PARKS AND COMMUNITY SERVICES DEPARTMENT

February 2, 2024

Subject: Grandview Reserve Phase II PUD Development Plan and Preliminary Plan (PUDSP-24-006)

LANDSCAPE  
 PRELIMINARY LANDSCAPE PLAN (OVERALL)

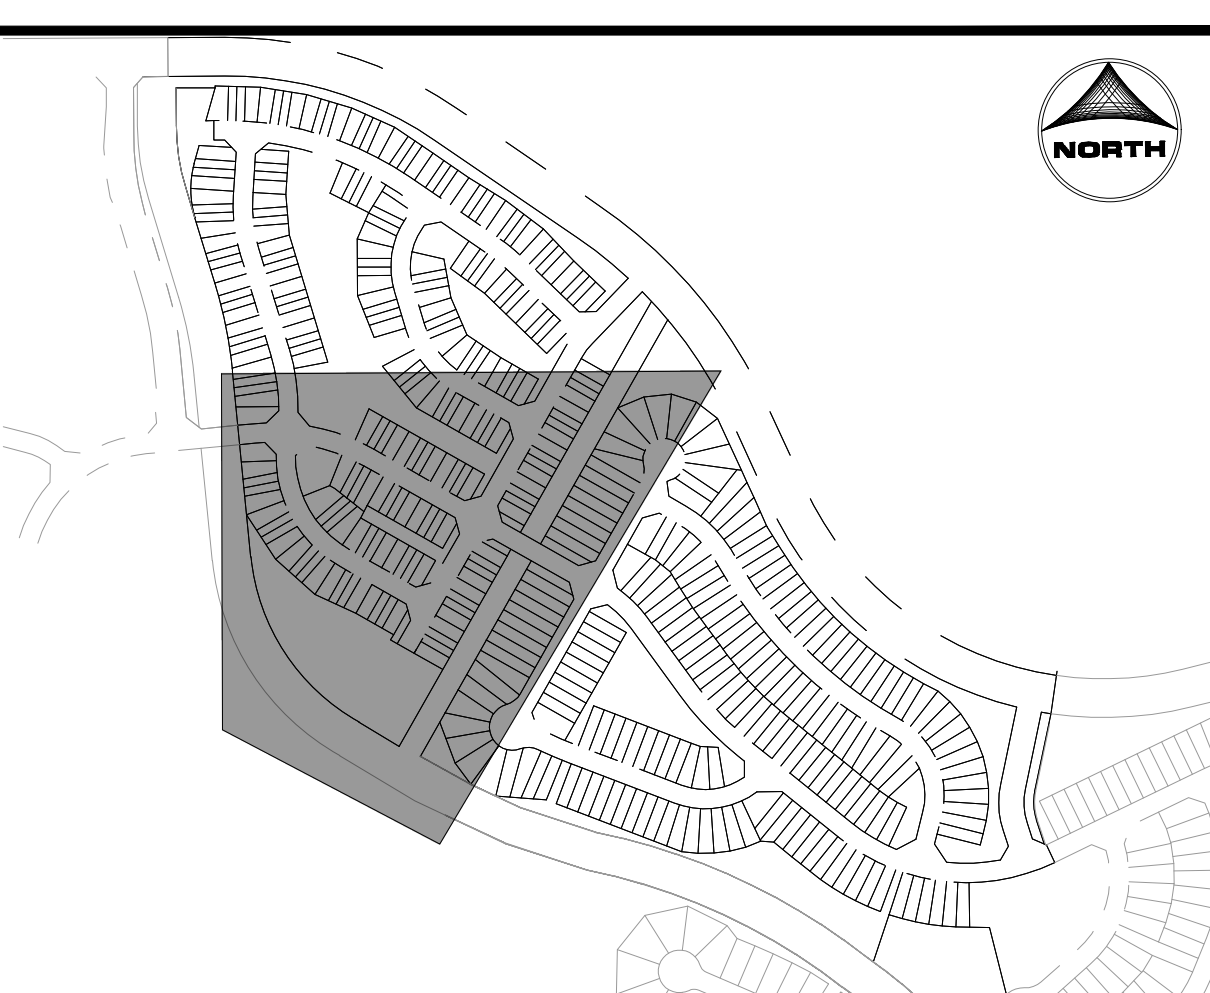
EPC staff is encouraged by the applicant's willingness to provide extensive recreational amenities for its residents and citizens of El Paso County through the development of an expansive and connected park, trail, and open space system. Staff recommends that the applicant submit detailed site plans for the proposed neighborhood park and include multi-generational recreational amenities such as a playground, multi-use turf field, and/or seating and picnic areas. The submitted Landscape Plans are rather limited and only show half of the proposed park area.

The Park Advisory Board recommends that the Planning Commission and the Board of County Commissioners include the following conditions when considering and/or approving the Grandview Reserve Phase II PUD Development Plan and Preliminary Plan: (1) provide detailed site plans for the proposed neighborhood park; (2) fees in lieu of land dedication for regional park purposes in the amount of \$211,090 and urban park purposes in the amount of \$126,654 will be required at time of the recording of the forthcoming Final Plat(s). A Park Lands Agreement may be an acceptable alternative to urban park fees provided the agreement is approved by the County and executed prior to recording the forthcoming Final Plat(s).
